DELEGATED HOUSEHOLDER DECISION

Item No.	Report of the Interim Director of Planning, Regeneration & Public Realm	
Address	2 HALFORD ROAD ICKENHAM	
Development:	Raising of roof to provide habitable accommodation within loft space, to include a double hip to gable conversion, roof lights, front and rear dormers, and erection of a two-storey side/rear extension, rear patio and external alterations to property (Revised description, no changes to the submitted drawings)	
LBH Ref Nos:	56582/APP/2022/3337	
Drawing Nos:	100588 - 1500 Rev. A 100588 - 1100 Rev. A 100588 - 3100 Rev. B 100588 - 3500 Rev. B Site Location Plan	
Date Plans Received:	01/11/2022	Date(s) of Amendment(s):
Date Application Valid:	01/11/2022

Section A - A

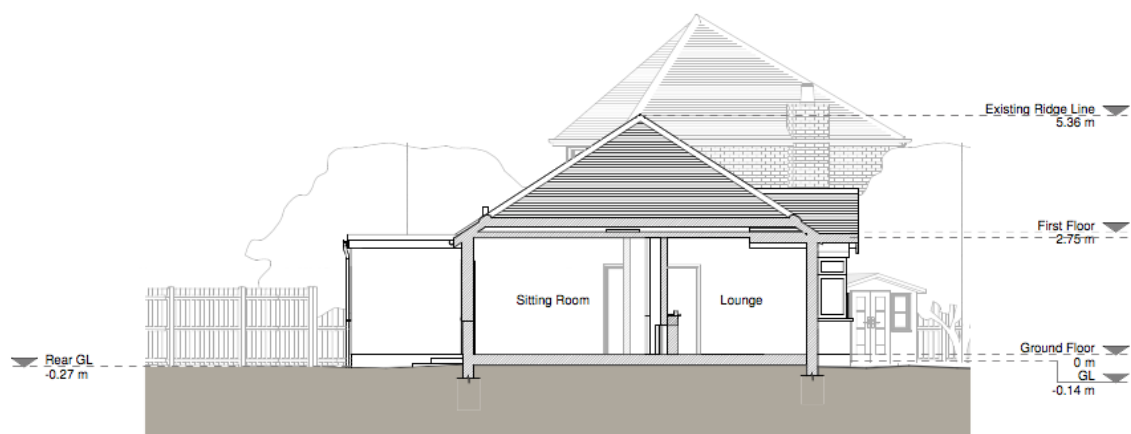
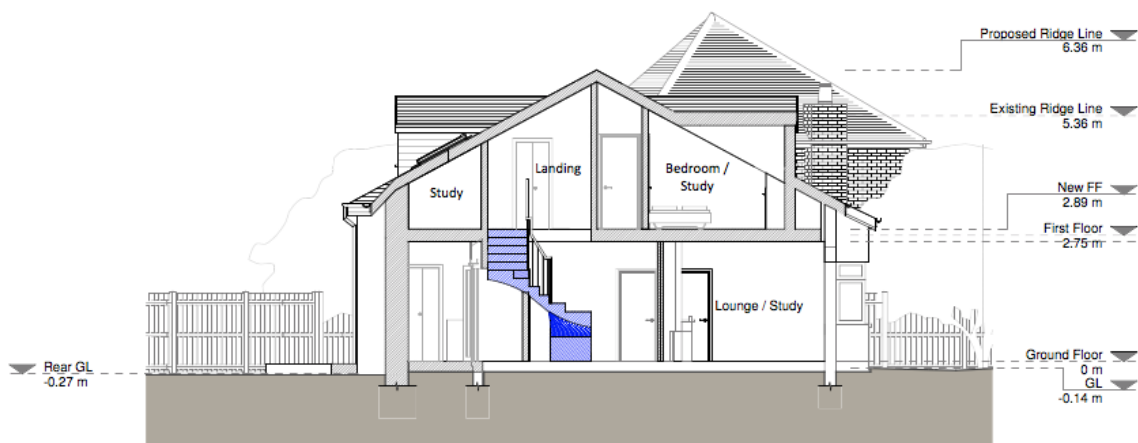
No. 100 Long Lane is a two-storey dwelling located to the north of the site. This neighbouring property is set forward of the application property. As a result, the proposed two storey side/rear extension would project beyond the rear building line of No. 100 by approximately 8.5 metres, which is a substantial distance. This coupled, with the proposed bulk and height of the new two-storey gable flank wall of the host dwelling would be unacceptably imposing, resulting in a loss of outlook, sense of enclosure and overbearing impact for the occupiers of No. 100 when viewed from their habitable rear windows and private rear garden.

It is acknowledged that there would be a separation distance of approximately 4 metres (at the closest point) between the proposed two-storey flank wall of the resulting host dwelling and the mutual boundary shared with No. 100. However, this distance in itself, is not considered to be sufficient to address the harm that has been identified in the preceding paragraph. Furthermore, whilst the rear building line of the proposed development would match the existing single storey rear addition, the overall bulk, scale and height of the development would be substantially greater than the existing circumstances.

The proposed development, by virtue of its proximity, depth, size, scale, bulk and height of the new proposed two-storey side gable wall, would have a harmful impact on the living conditions of the neighbouring occupiers at number 100 Long Lane and their associated private amenity space, in terms of outlook, overdominance, sense of enclosure and overbearing impact. The proposal is therefore contrary to Policy BE1 of the Hillingdon Local Plan: Part One - Strategic Policies (2012), Policies DMHD 1 and DMHB 11 of the Hillingdon Local Plan Part Two - Development Management Policies (2020) and the National Planning Policy Framework (2021).

Proposed Plans:

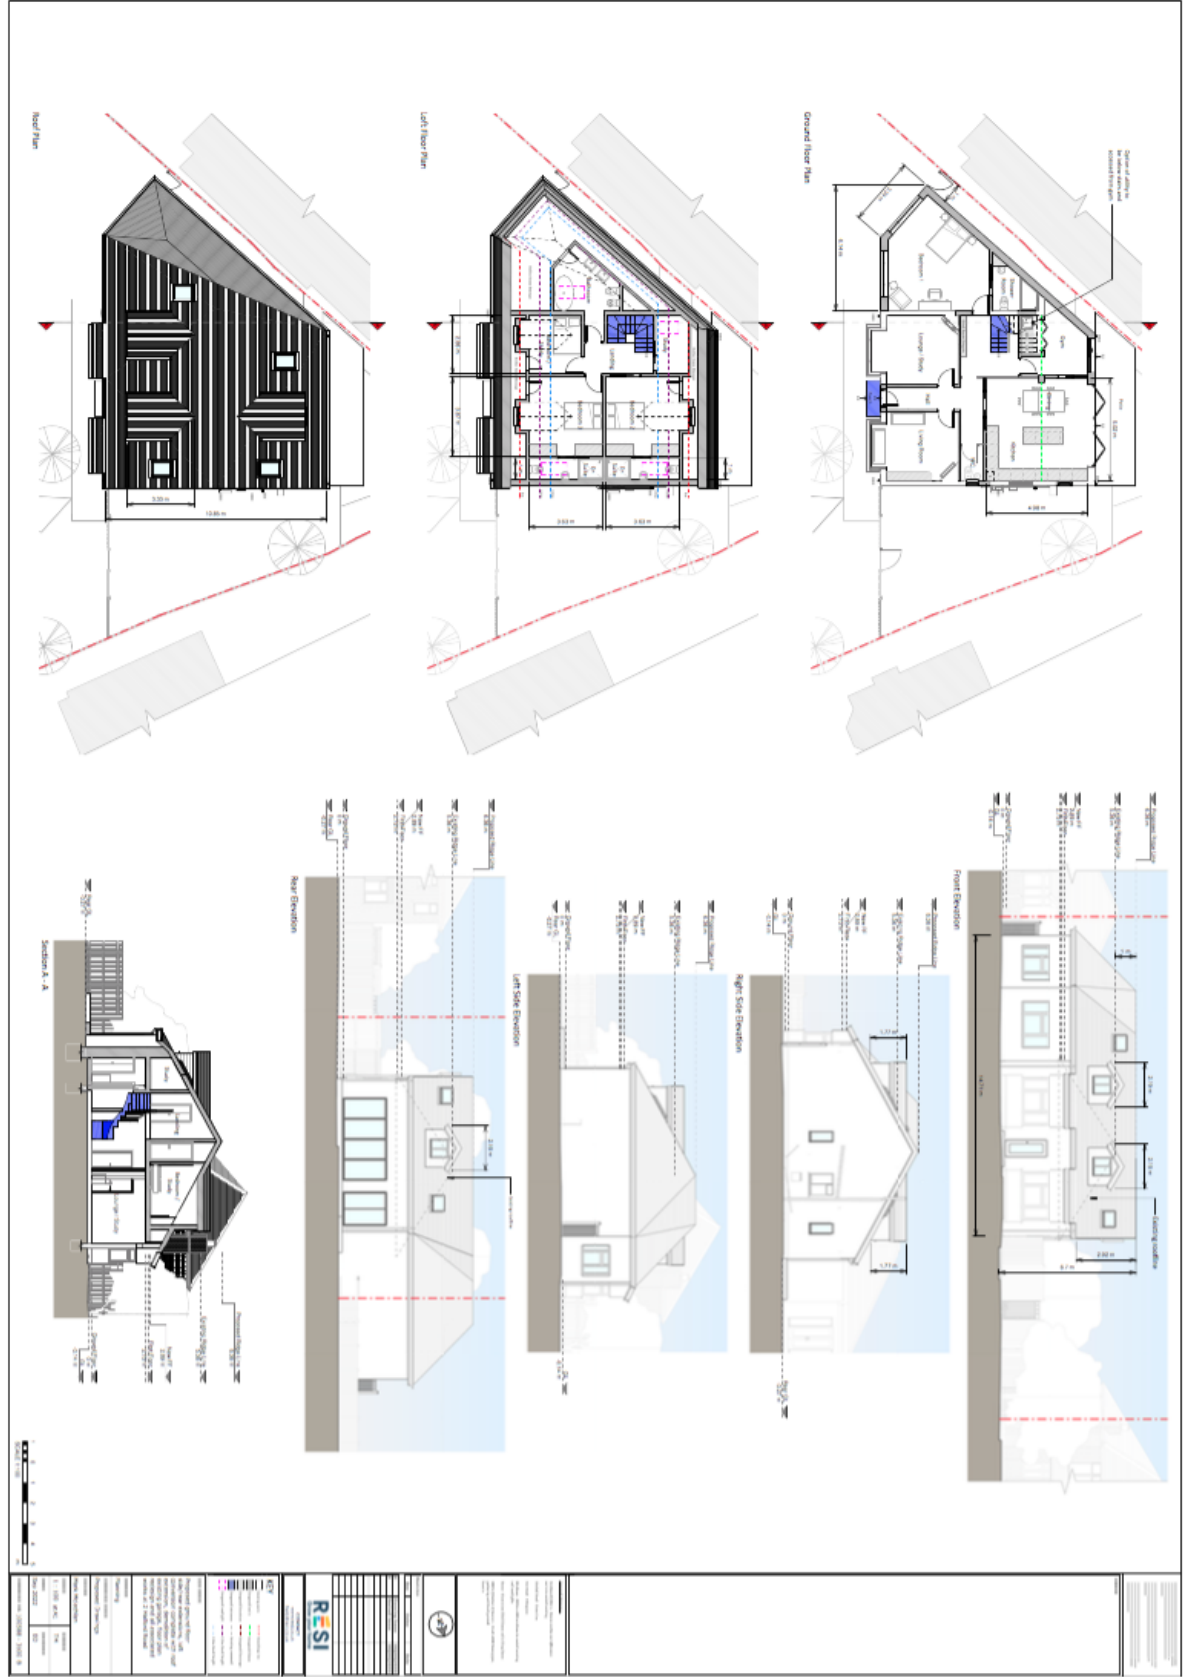
The proposal, which includes the raising of the roof, front and rear dormers, a double hip to gable conversion and the erection of a two storey side/rear extension, would substantially alter the appearance of the property. The significant increase in the overall size, scale, bulk and massing of the host dwelling would result in an incongruous form of development. It is considered that the proposed development, when viewed as a whole, would be completely disproportionate and unsympathetic to the original architectural composition of the host dwelling. Thus, resulting in the proposed development having a harmful impact to original dwelling, street scene, and the surrounding area which includes the setting of Ickenham Village Conservation area.

The proposed part two storey side/rear extension would not be set-back from the original main front wall of the host dwelling, nor would it be set-down from the main ridge. As a consequence, it is considered that the proposed two-storey side/rear extension would overwhelm the host dwelling, rather than appear subordinate to the original host dwelling.

The proposed double hip to gable conversion coupled with the front dormers would appear out of character with the immediate vicinity of the site, where it is observed that no

In this context, it is considered that the proposed roof form on the main host dwelling, when coupled with the roof profile on the proposed two-storey side/rear extension and dormers, would result in an incongruous and top-heavy building that fails to respect the character of the area, which includes the setting of the adjoining Ickenham Village Conservation. Whilst it is recognised that there is existing boundary treatment along the site frontage, views of the upper part of the proposed development would nonetheless be visible from various public vantage points, due to the prominent position of the site.

Notwithstanding the above, the proposed rear dormer window serving a bedroom would be considered to result in an unacceptable degree of overlooking to no. 4 Halford Road and its rear garden. Whilst oblique views of neighbouring gardens would not be uncommon in an urban area, in this particular case, as a result of the orientation of the properties, the proposed dormer window would directly overlook 4 Halford Road at close proximity. Given that no first floor windows currently exist at 2 Halford Road, the proposed dormer would introduce an unacceptable degree of overlooking and loss of privacy.

The proposed raising of the roof, double hip to gable conversion, front dormers and two storey side/rear extension, by reason of their cumulative size, scale, bulk, height and design (including uncharacteristic roof profiles), would result in a disproportionate,

The proposed development, by virtue of the proposed rear dormer window, would have a harmful impact on the living conditions of the neighbouring occupiers at number 4 Halford Road and their associated private amenity space, in terms of overlooking and loss of privacy. The proposal is therefore contrary to Policy BE1 of the Hillingdon Local Plan: Part One - Strategic Policies (2012), Policies DMHD 1 and DMHB 11 of the Hillingdon Local Plan Part Two - Development Management Policies (2020) and the National Planning Policy Framework (2021).
